From: Amanda Scholes on behalf of Planning.Responses
Sent: 16 August 2017 10:28
To: Planning Scanning
Subject: FW: Fitzalan Link - LU.234.16.RES - Fitz RSA1 Addendum Response Report

Subject: RE: Fitzalan Link - LU.234.16.RES - Fitz RSA1 Addendum Response Report

Thank you for your two emails dated 9th August 2017 – one with Addendum Stage 1 Road Safety Audit (August 2017, Project Code: S/PHFITZ.1.1AD.6a) – and the other, the Designer's Response (dated 8th August 2017), Addendum Safety Audit Brief (July 2017, Project Code: A/PHFITZ.1) and previous Stage 1 Audit and Designer's Response (October 2011, Project Code: WYGLITTLEHAMPTON.6A).

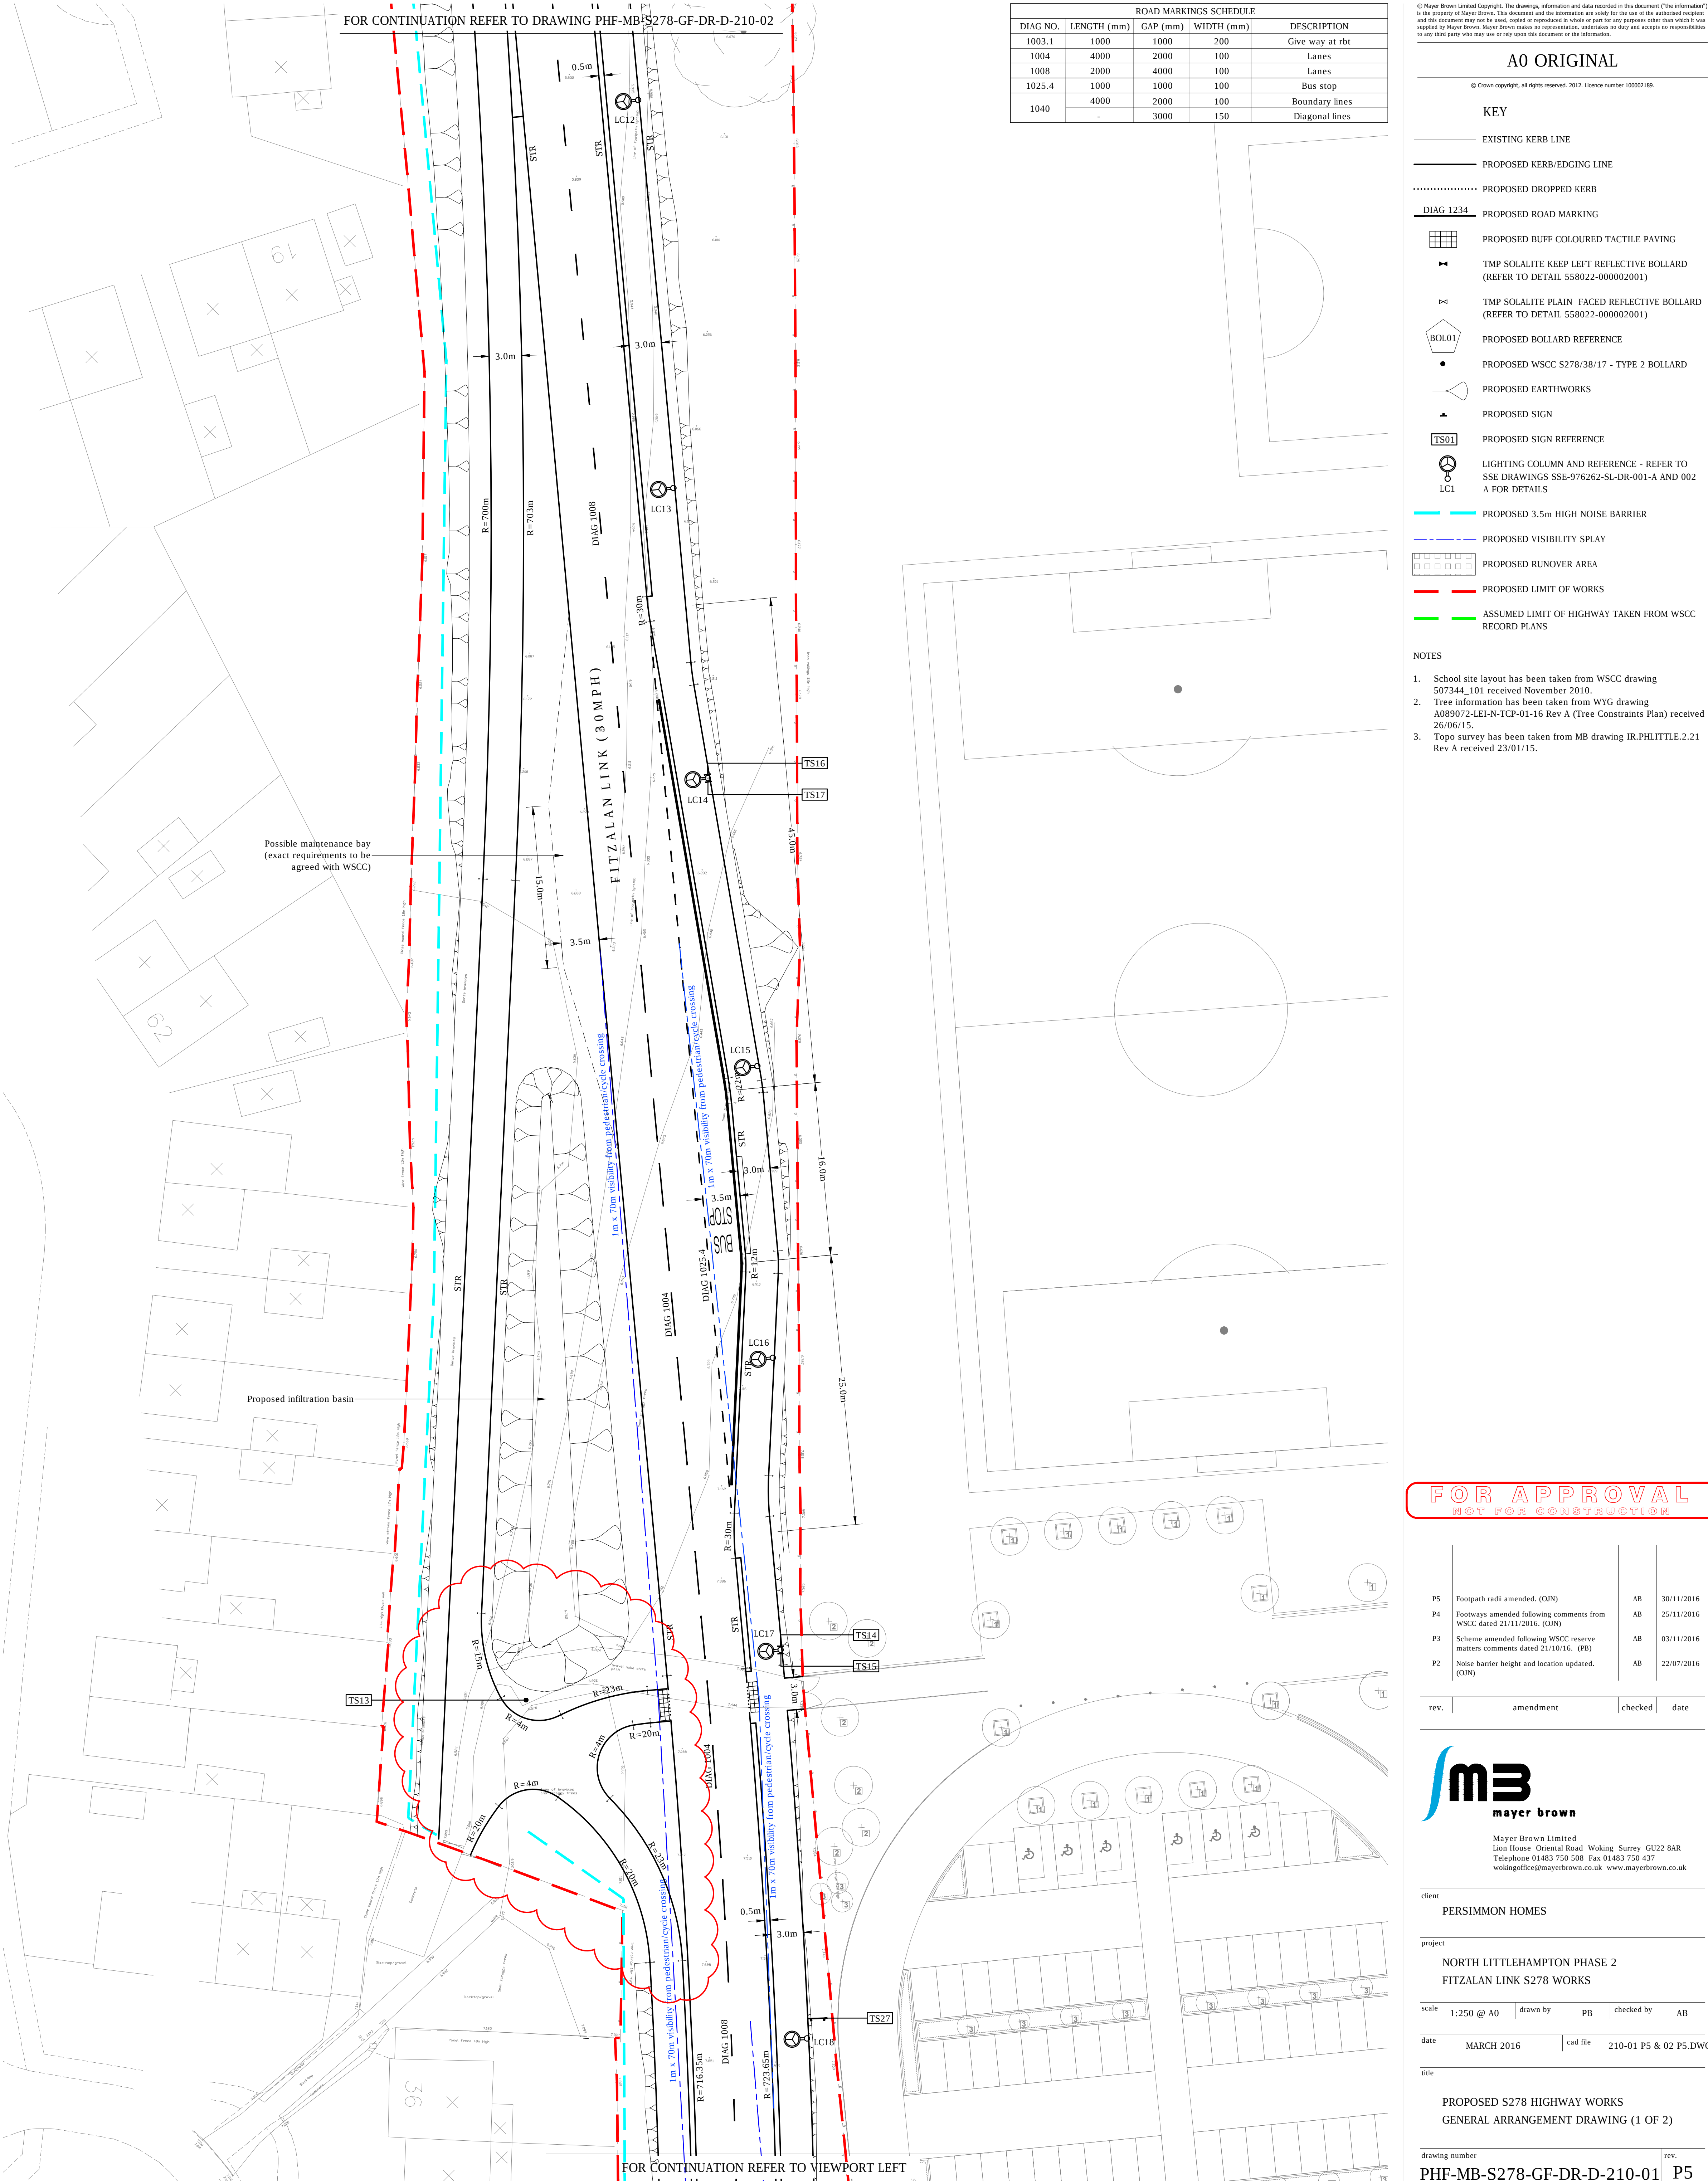
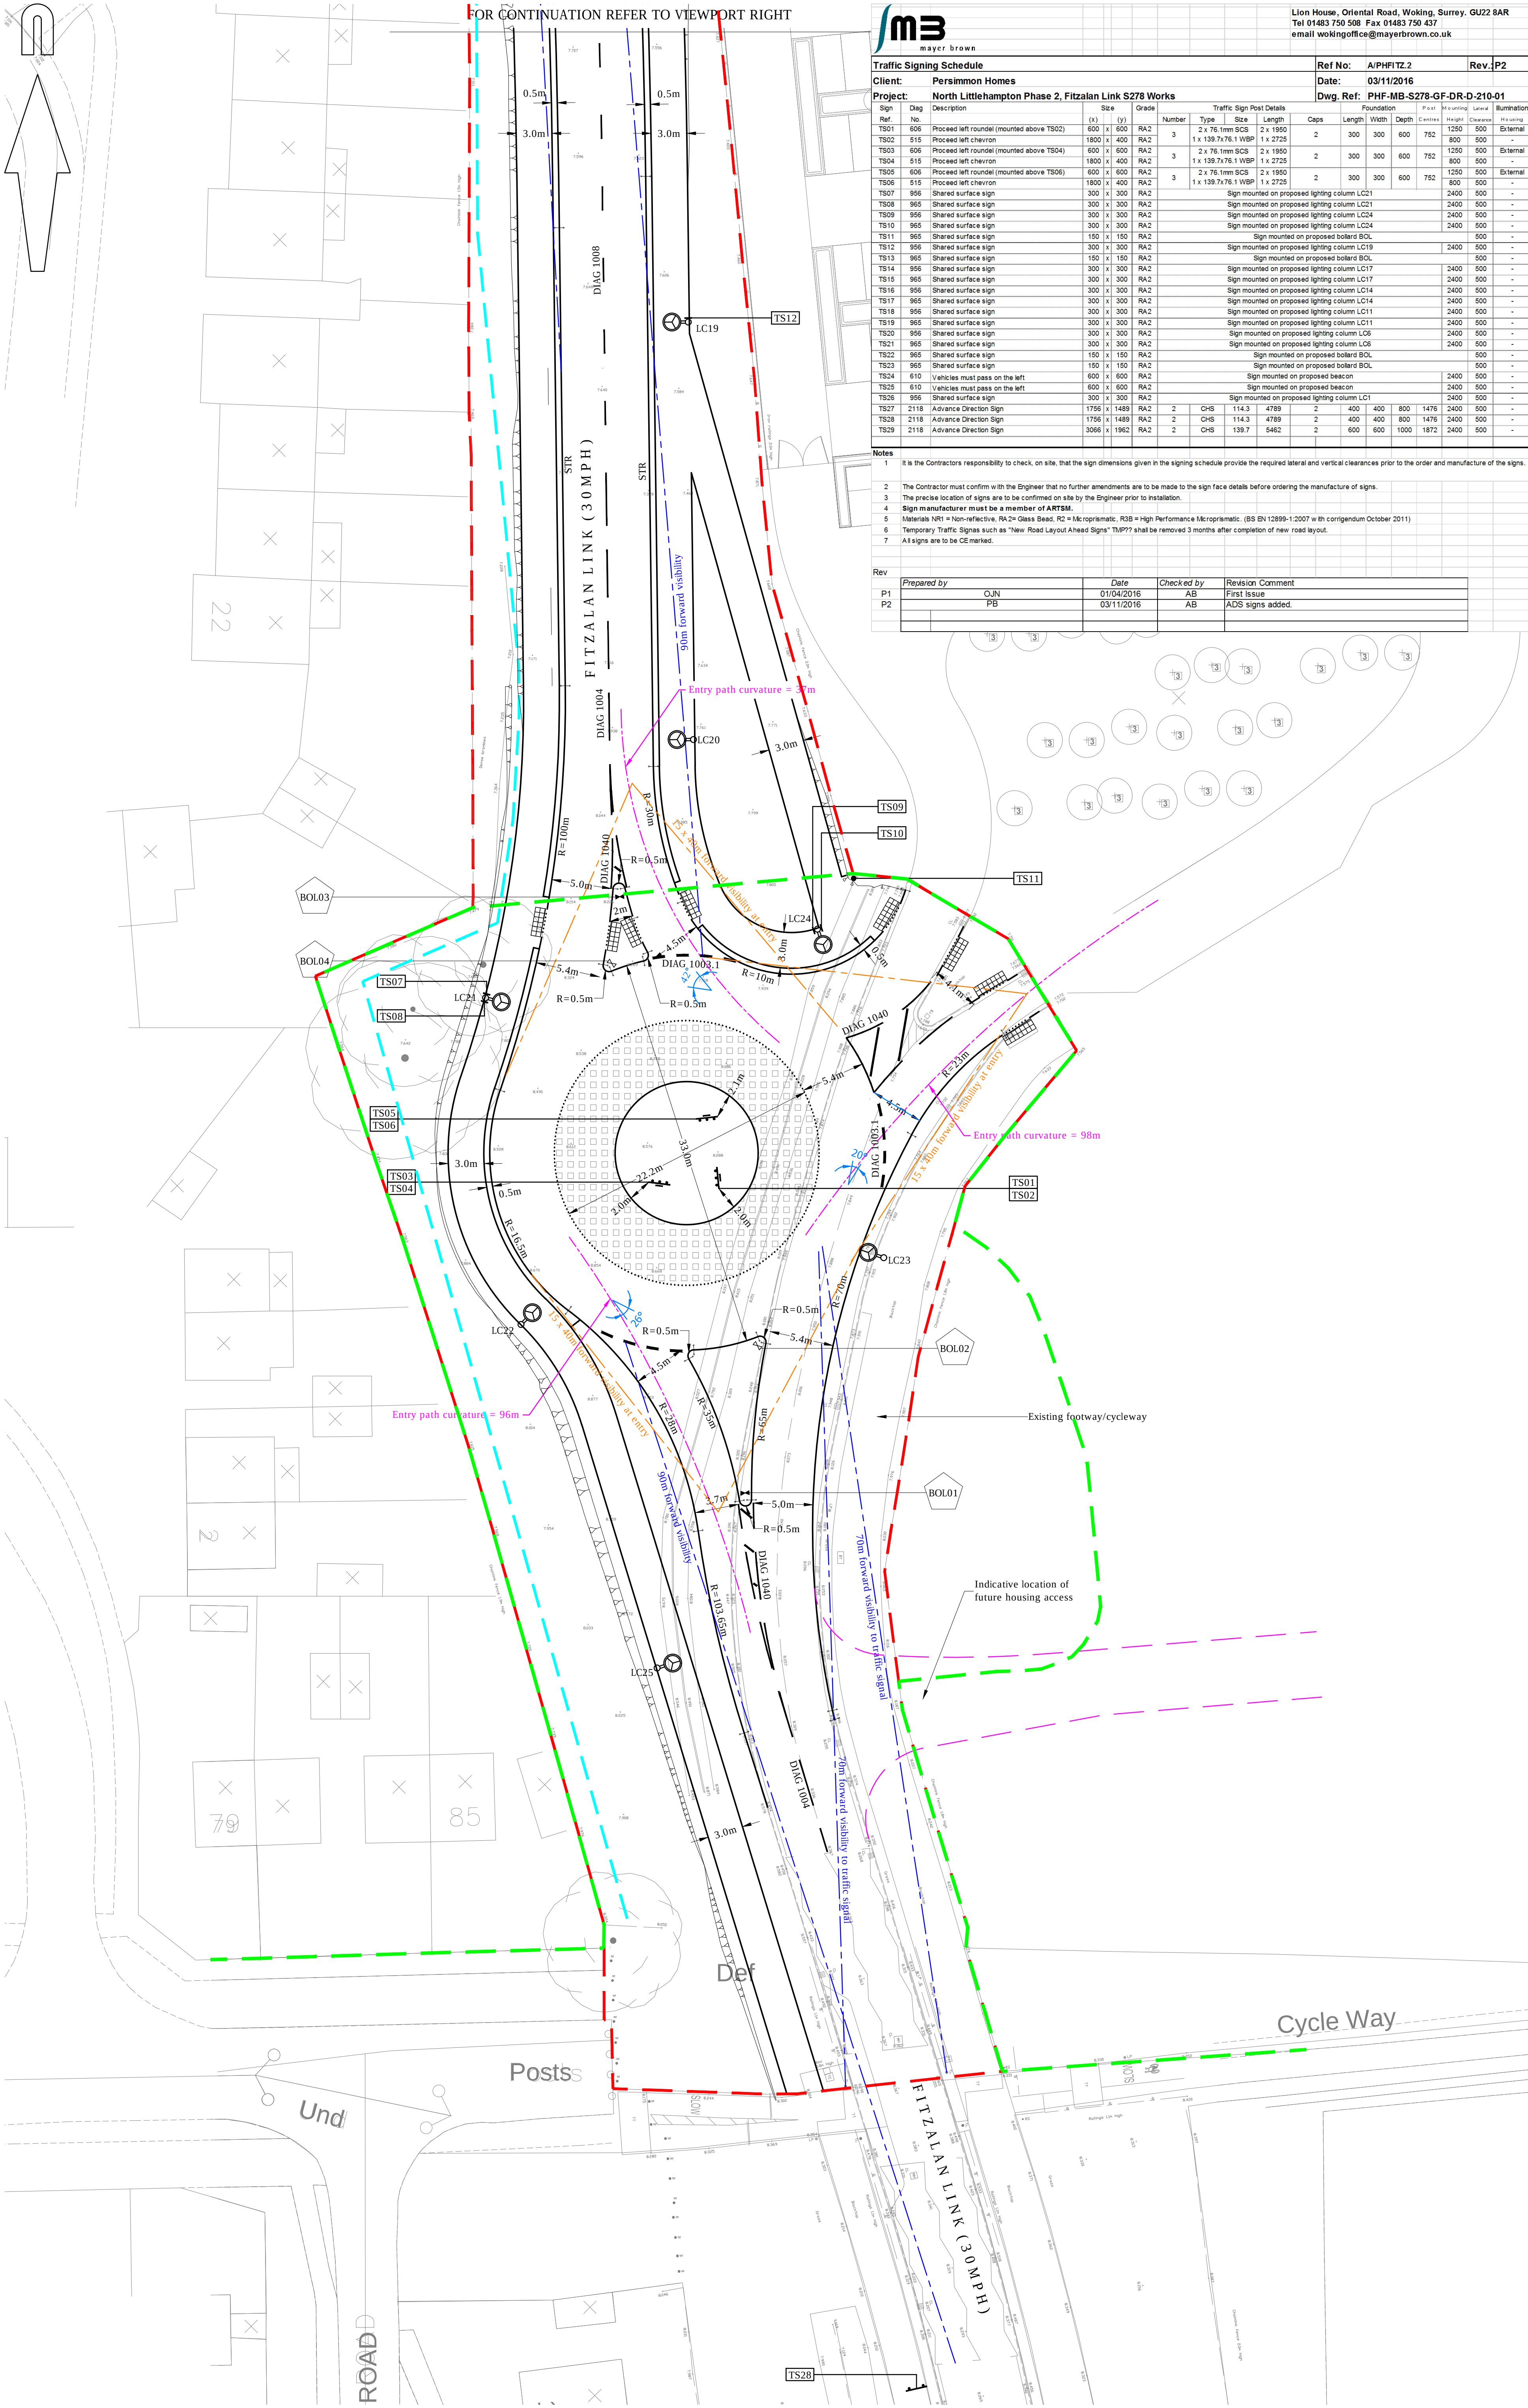
The drawings show a pervious road surface. This will not be long lasting enough. The best WSCC can consider is a negative textured road surface. However, this will not absorb as much noise. Your designer will need to look into "German SMA" which is an SMA with a high binder content and use an appropriate noise reduction factor.

Academy roundabout northern traffic island has a tactile paved crossing point. Given that it is narrow (the tactile paving on the drawing appears to 'meet'), consideration should be given at the S38/S278 stage to widening it or adjusting the position of the tactile paving (if possible) to improve width for pedestrians. However, in doing this you should also ensure that the swept-path of vehicles can still adequately negotiate the roundabout without compromising safety for pedestrians on the island.

Recommend that at the detailed design stage, the cycleway on the east side be locally flared at the controlled crossing to provide additional width for waiting pedestrians and cyclists. Also, that LC 17 be moved to the very back of the space available, away from the area of conflict where there would be interaction between pedestrians and cyclists. WSCC recommended to increase the crossing width beyond the minimum so as to provide more space for waiting pedestrians in order to help keep the cycle route clear. The location of the control box must be carefully considered to avoid obstruction for users and visibility. Finally, it is recommended that corner radii be applied between the cycle paths at the school exit next to the crossing and that pedestrian and cycle intervisibility is provided at this location.

Thank you for showing a northbound bus stop and layby. Where possible (and again at the detailed design S38/S278 stage), additional path width should be provided at *both* bus stops to allow passengers to wait clear of the cycle path. Also, please consider where bus shelters might be placed, and what form these would take given the space available.

We sought to reduce carriageway of the road to 6.75m as this would have the effect of constraining speed closer to the proposed 40mph speed limit requested by WSCC. As a result, HRA (standard surface) could be provided. Our noise consultants have assessed the impact on noise relating to a speed limit of 40mph and with a HRA surface course finish (standard / noisiest surface) and this includes that speeds of 42mph would be okay in terms of the noise assessment submitted and enable a 3.5m noise barrier to provide sufficient noise mitigation. WSCC's 2010 speed policy refers to an average speed of 42mph for a 40mph road. Thus the above would appear appropriate. The CHA is satisfied with this now – details to be checked at S38/278 stage.

Noted. We shall review to see what changes can be made to accommodate a larger island as requested. Noted.

Noted. We shall review to see what changes can be made. Noted.

We have been clear that space is restricted to provide this late edition facility (which we are doing to accommodate an WSCC oversight on the section of the Link Road they have already delivered) . We 'may' be able to provide an increased width footway of 3.5m on the western side, but we will need to review the levels so this can not be guaranteed and should not be used as a means to hold up this application. Otherwise, if the footpath width is crucial then we will not be able to provide a bus stop at all. In terms of bus shelters we can provide one but is likely to restrict foot / cycle path width even more. Furthermore, this seems a bit onerous given that the outline doesn't actually require us to provide a bus stop. We consider that an open bus stop is appropriate, especially given the width restriction and if a shelter becomes necessary at a later stage WSCC could fund this with wider infrastructure contributions. As stated previously, details will be reviewed at the S38/278 stage.
